Recommendation Report for Planning Permission for Works or Extension to a Dwelling

REF NO: P/11/15/HH

LOCATION: 31 Swandene
Pagham

PROPOSAL: Rear extension & garage conversion (resubmission following P/112/14/HH).

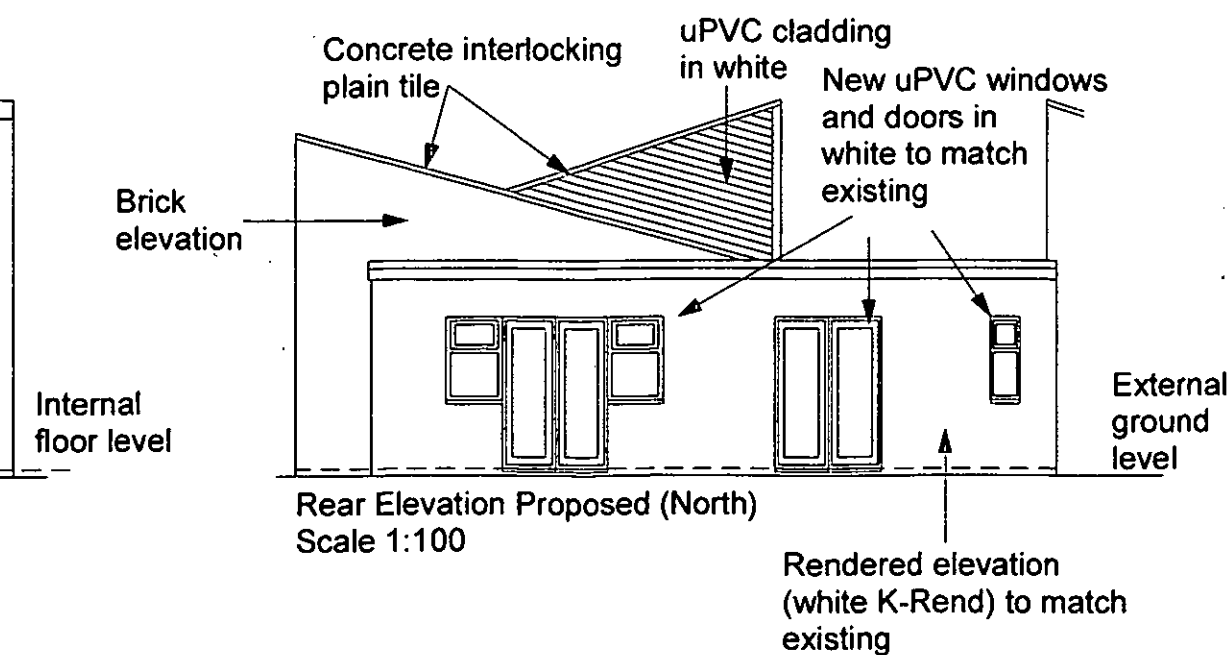
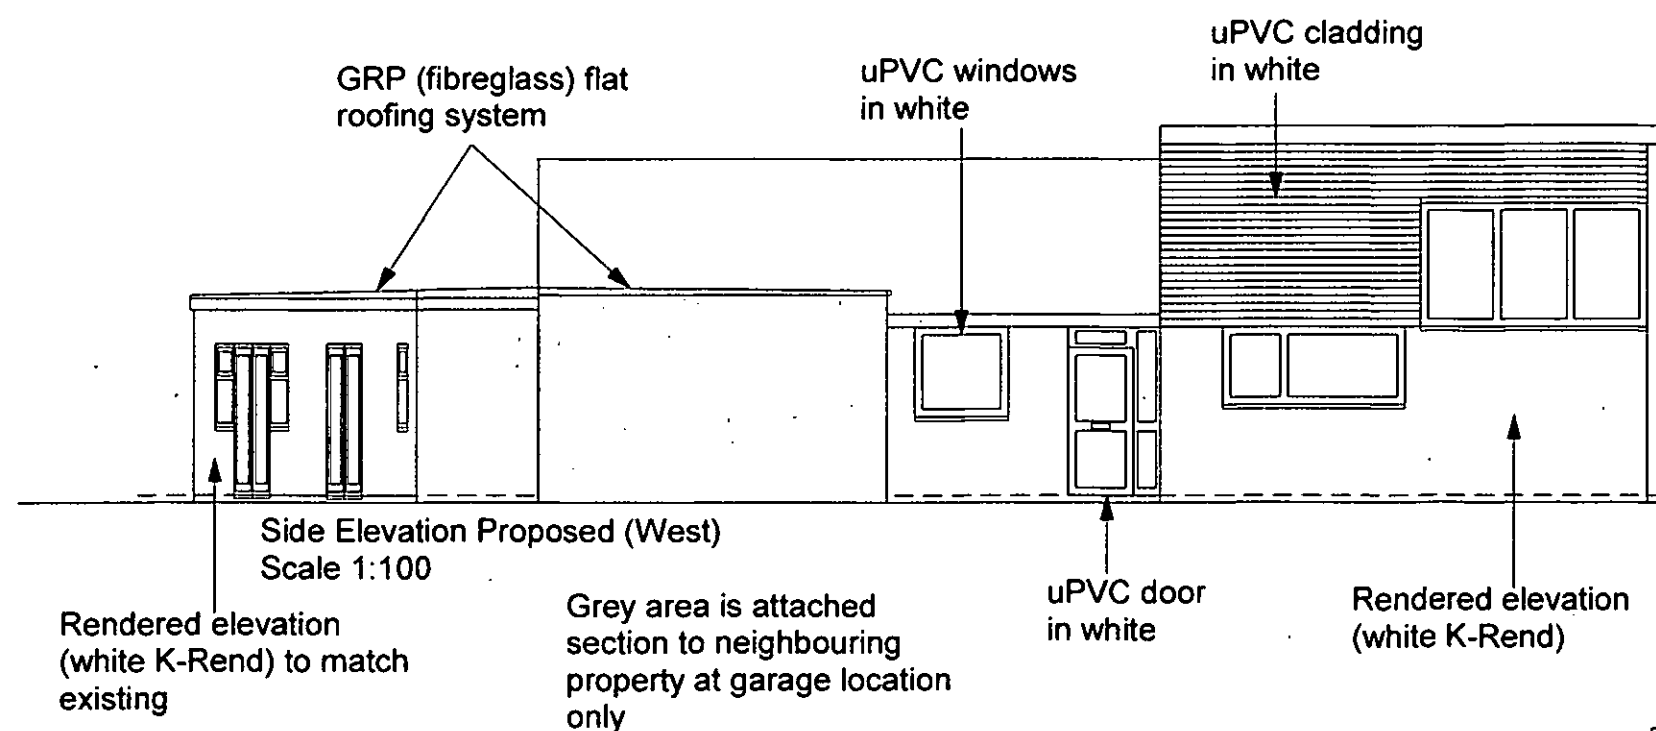
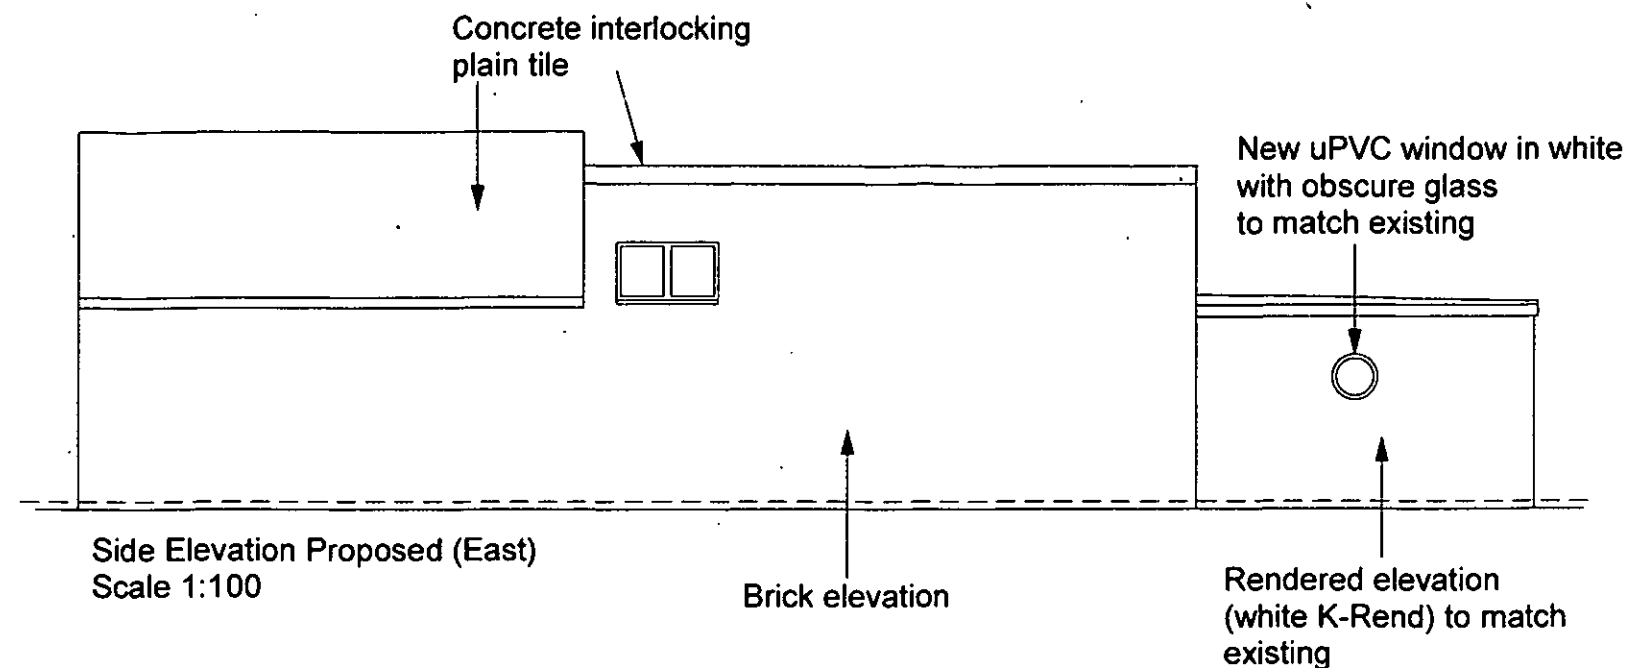
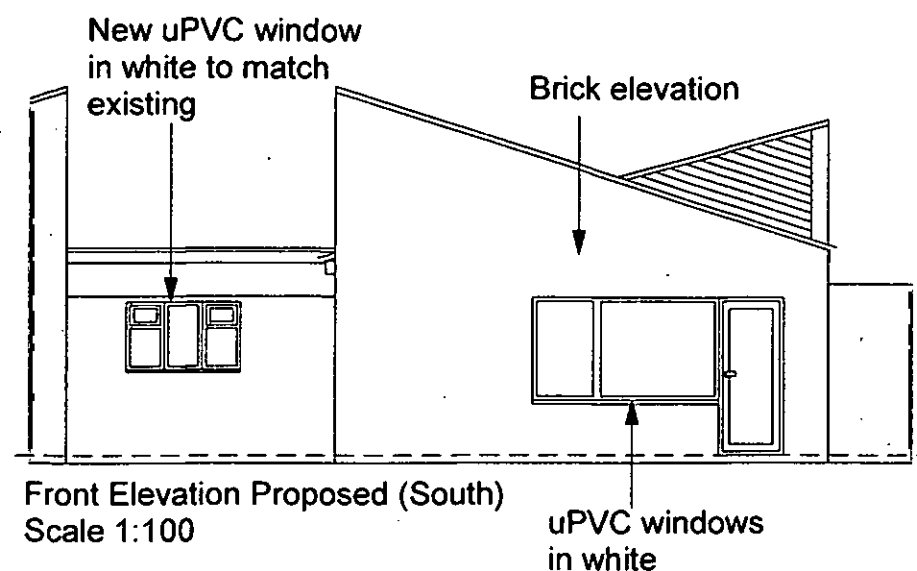
- 3 The window on the east side elevation of the building shall at all times be glazed with obscured glass.

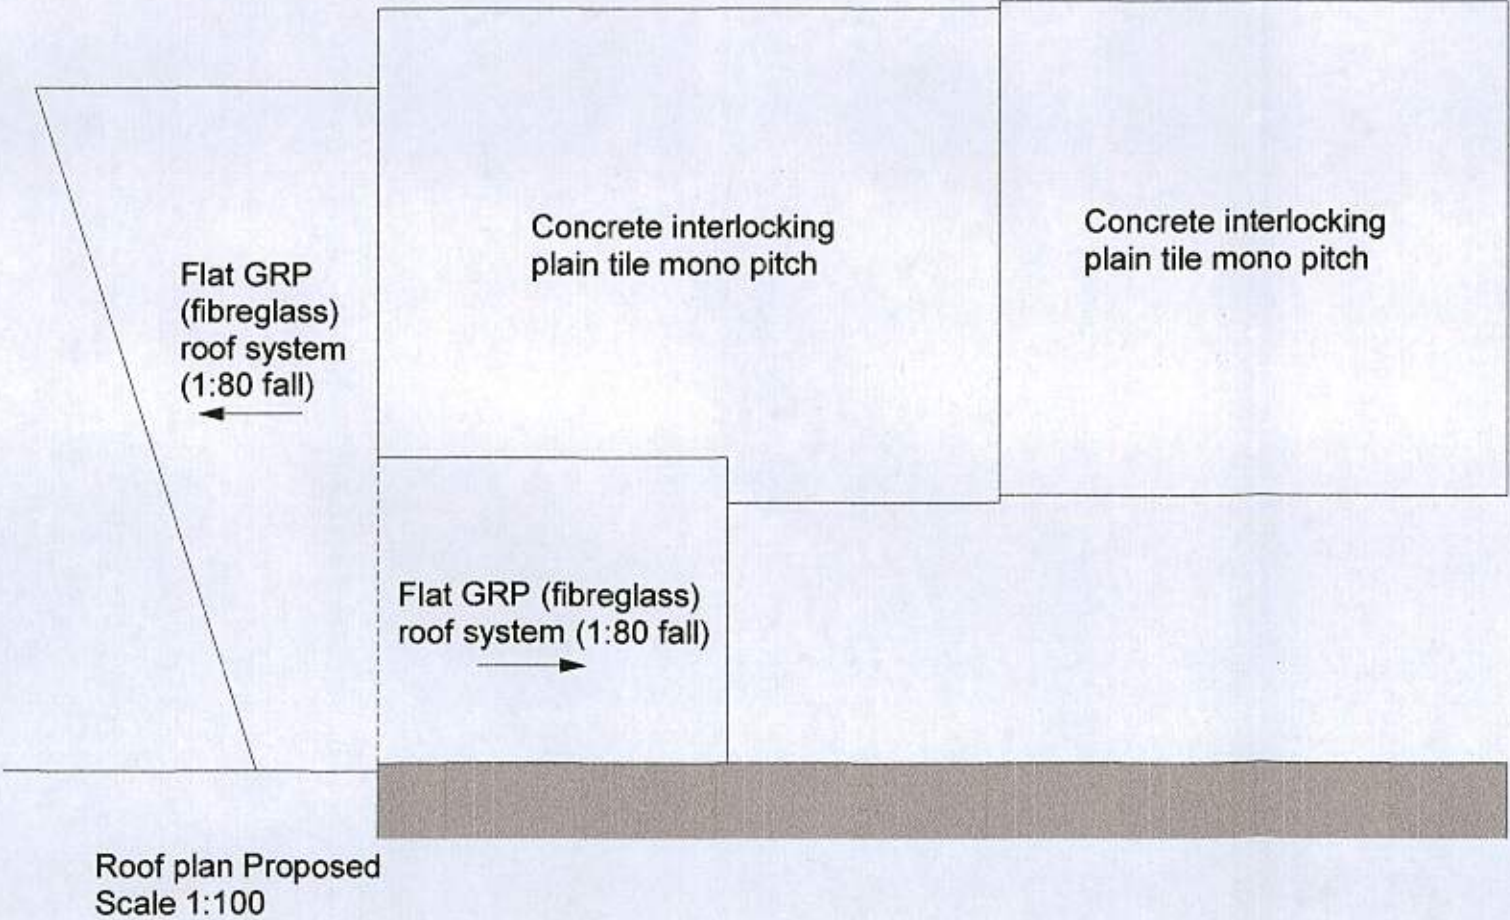
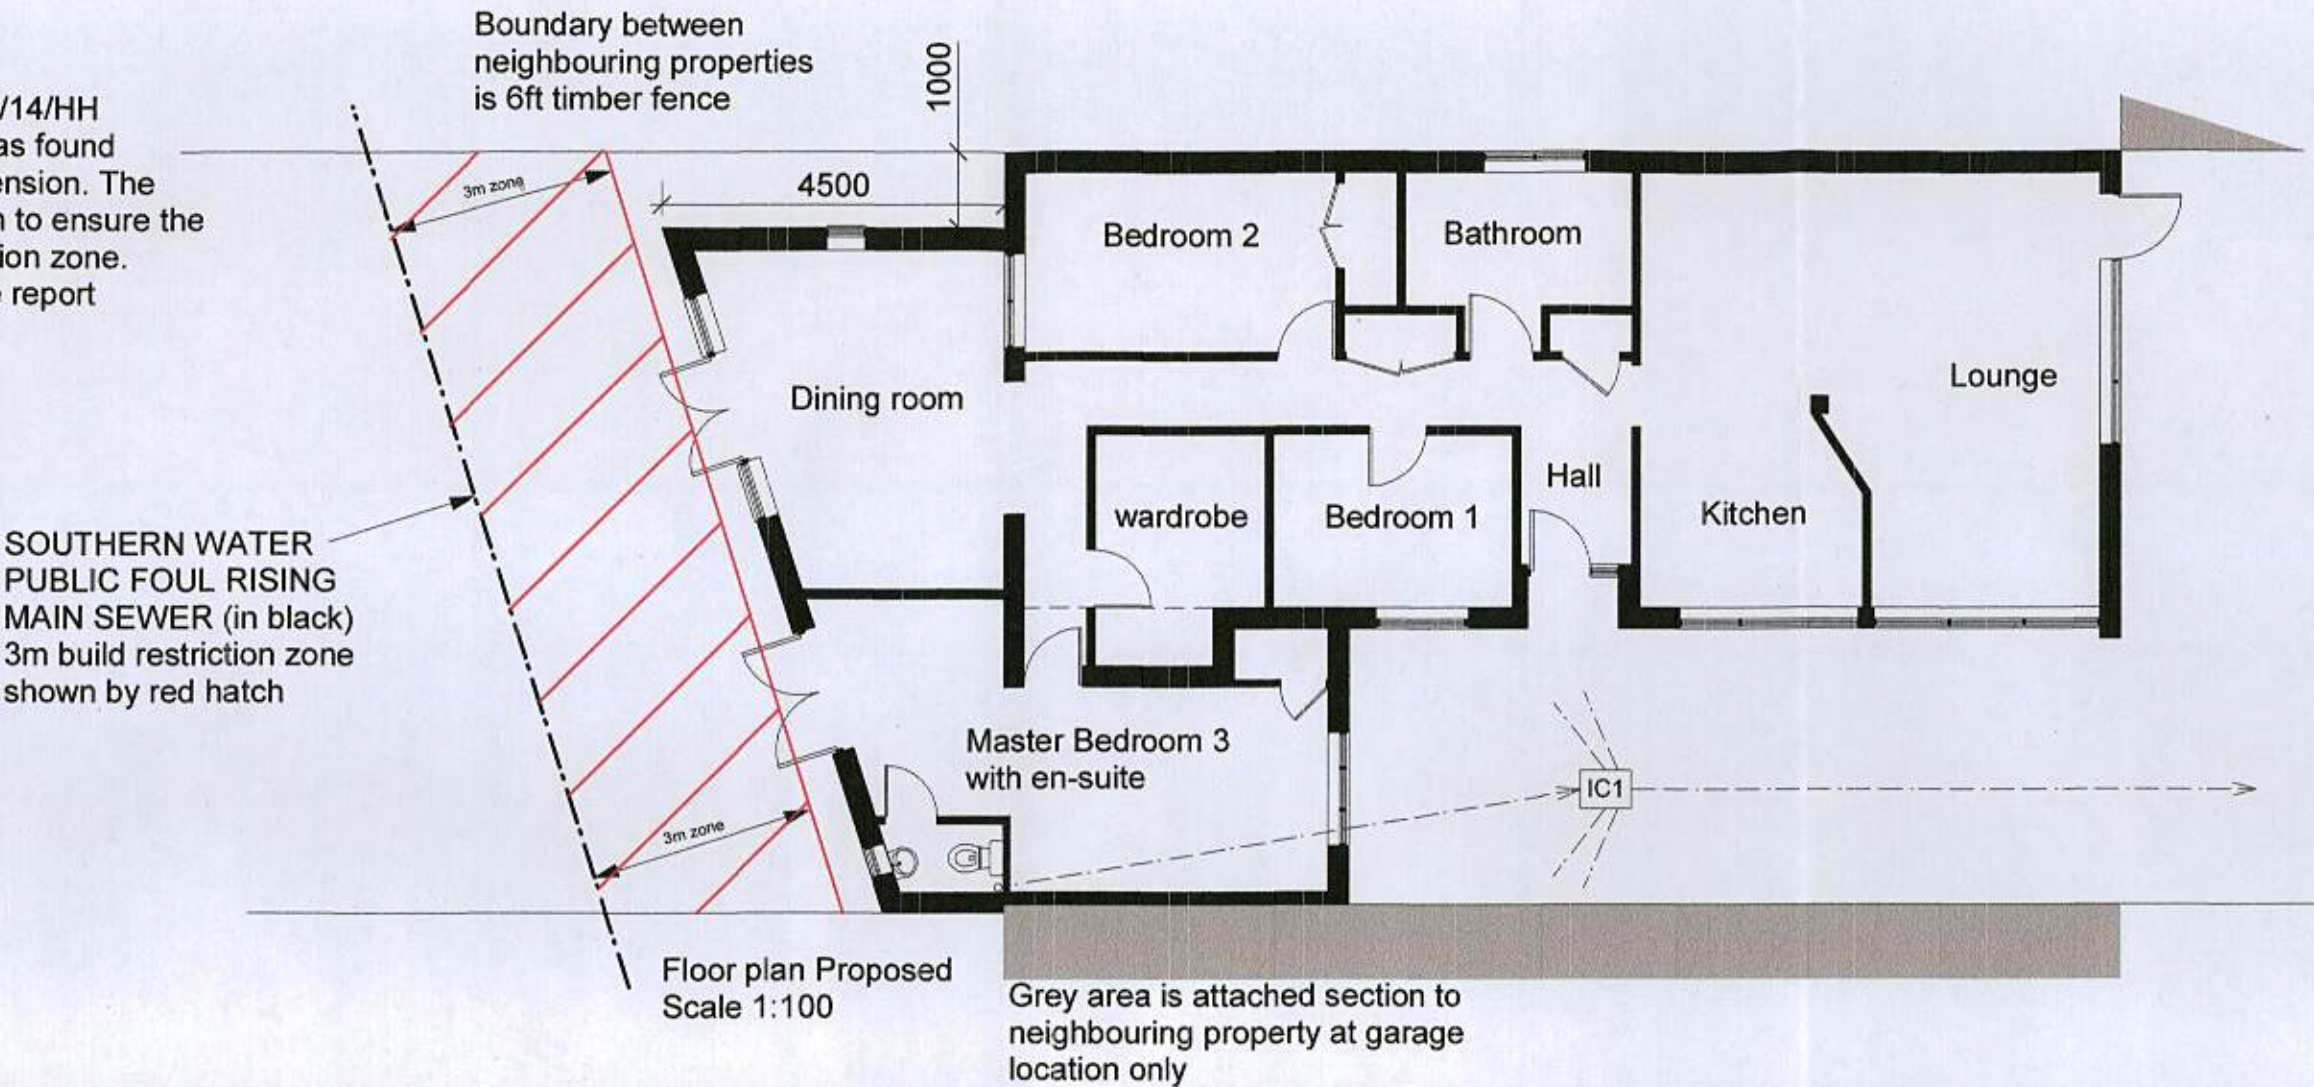
The extension which has been reduced in depth on the western side from 4.5m to 1.6m as it was found that a public foul rising main sewer was located across the proposed extension as previously approved. The extension is now located more than 3m away from the main sewer and 3m restriction zone. The garage is to be converted with the removal of the up and over doors and new window installed on the front which will match the existing windows.

With regard to residential amenity the neighbouring property to the west No 29 has an extension on the rear of the dwelling. The proposed extension will be sited to the boundary with No 29 and at this point will have a rear projection of approximately 1.6m. The Council as a consideration in determining planning applications have adopted a 45 degree rule which is used as a tool to balance the interest of those persons wishing to extend their premises and their neighbours by ensuring that extensions do not seriously affect a neighbours outlook or daylight. In this instance the 45 degree line has been taken from the middle point of the patio doors on the extension and complies with this rule.

The neighbouring property to the east No 33 is sited forward of No 31 and this property has a flat roof extension on the rear which projects out by approximately 3m. The proposed extension will be sited approximately 1m from the eastern side boundary and at this point will have a rear projection of 4.5m. The 45 degree line has been taken from the middle point of the patio doors and is slightly short of this rule. It should be noted that an extension with a depth of 4m could be constructed under "Permitted Development" without the need for the submission of a formal planning application. The existing conservatory has a depth of 3.5m and the proposed extension will be approximately 1m deeper than the existing. To provide additional light into the extension a high level window is proposed on the east side elevation which will be obscure glazed. With its flat roof to a height of 2.8m and boundary fencing to a height of 1.8m it is not considered that the extension would give rise to a loss of outlook and daylight to the occupiers of No 33 to recommend refusal.

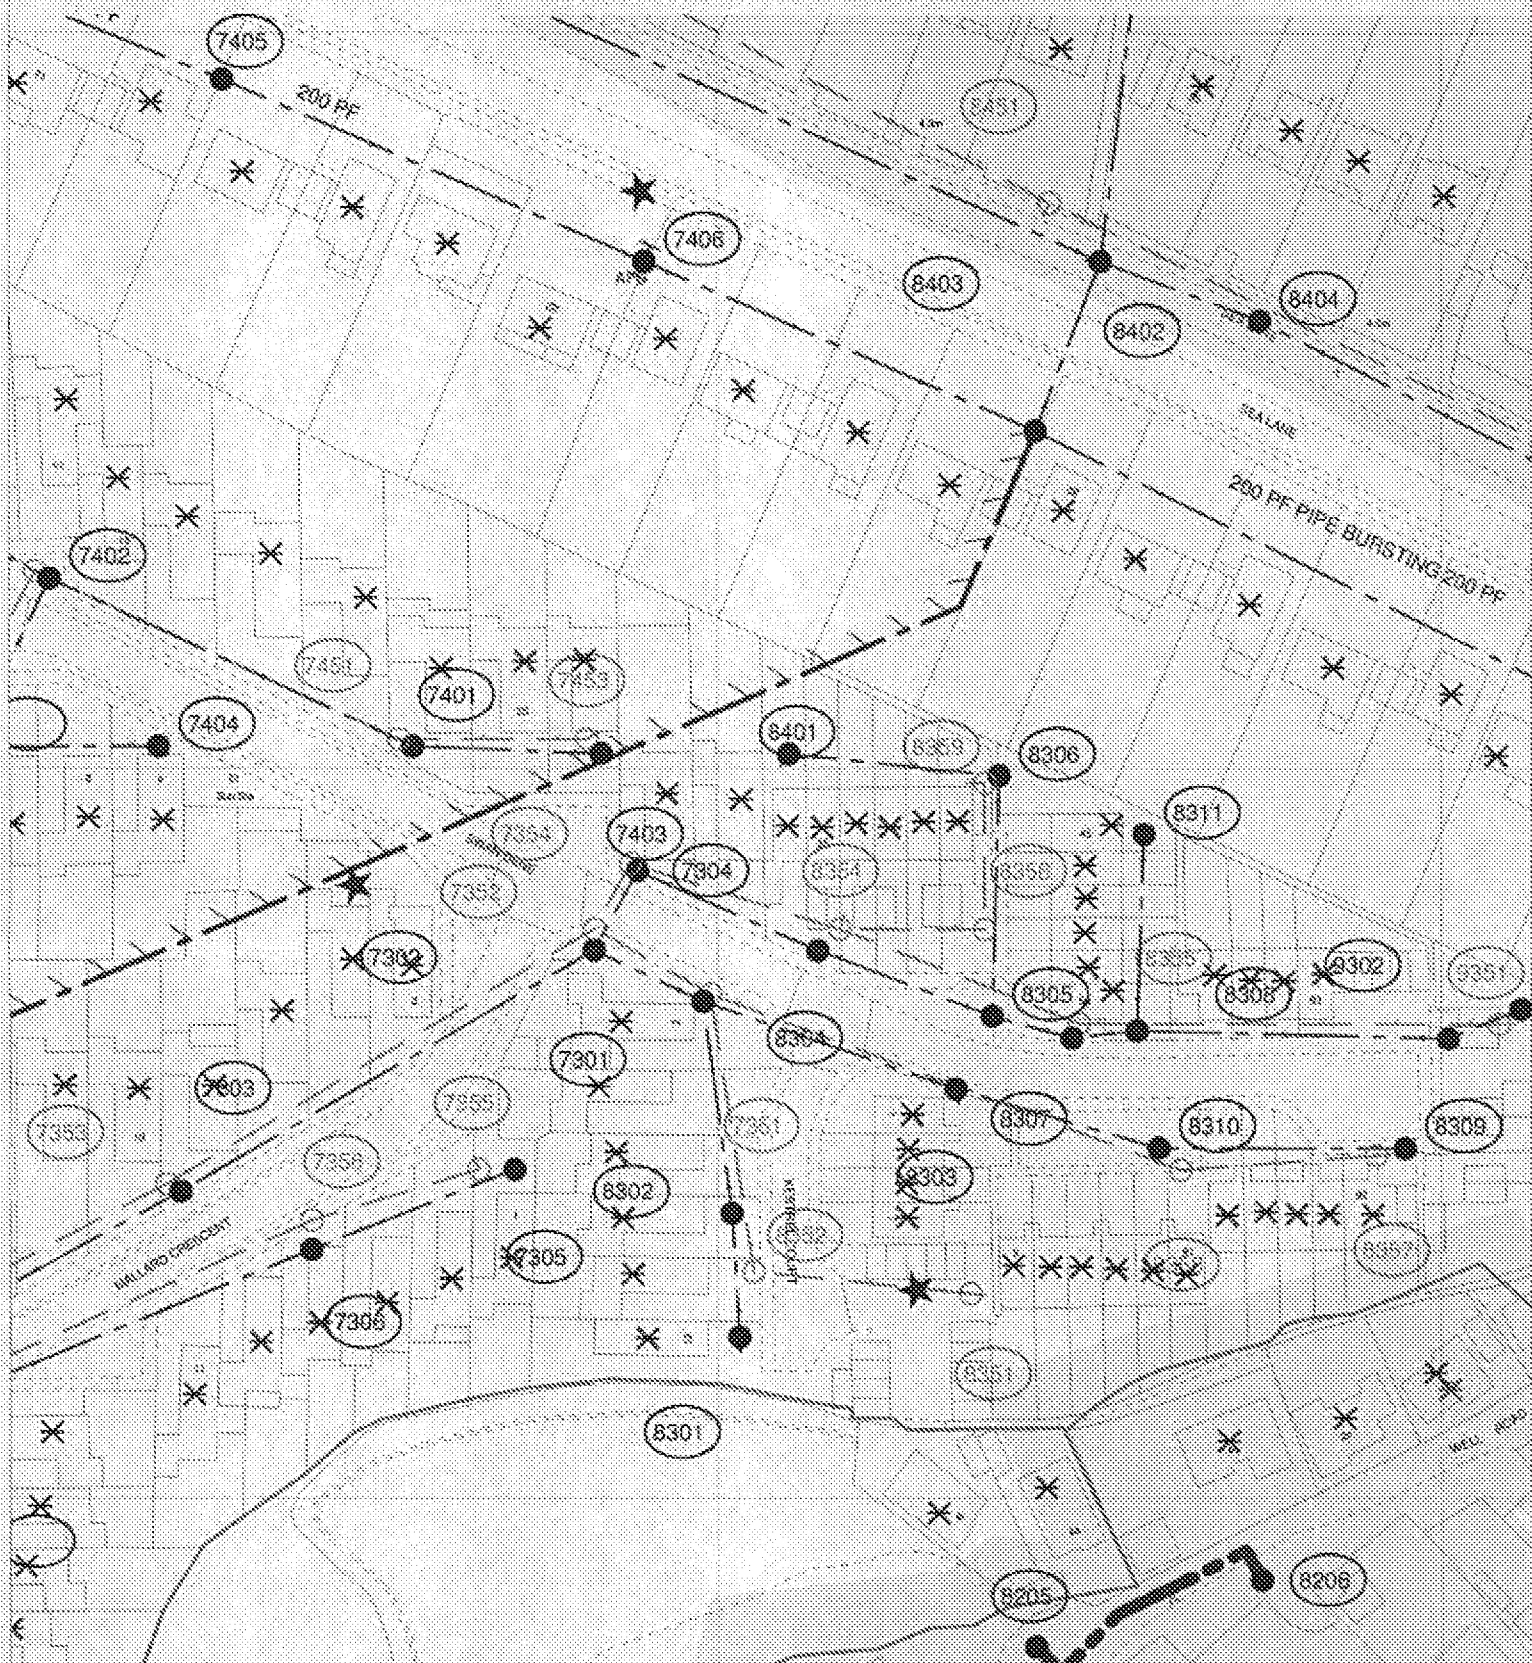
The exact position of the public foul sewer, foul rising main and surface water sewer crossing the site. The exact position of the foul and surface water sewer must be determined on site by the applicant before the layout of the proposed development is finalised.

No development or new tree planting should be located within 3 metres either side of the centreline of the foul rising main.

No development or new tree planting should be located within 3 metres either side of the centreline of the foul sewer and surface water sewer.

No new soakaways should be located within 5 metres of a public sewer.

Southern Water comments noted

If approved, an informative will be placed on any consent.
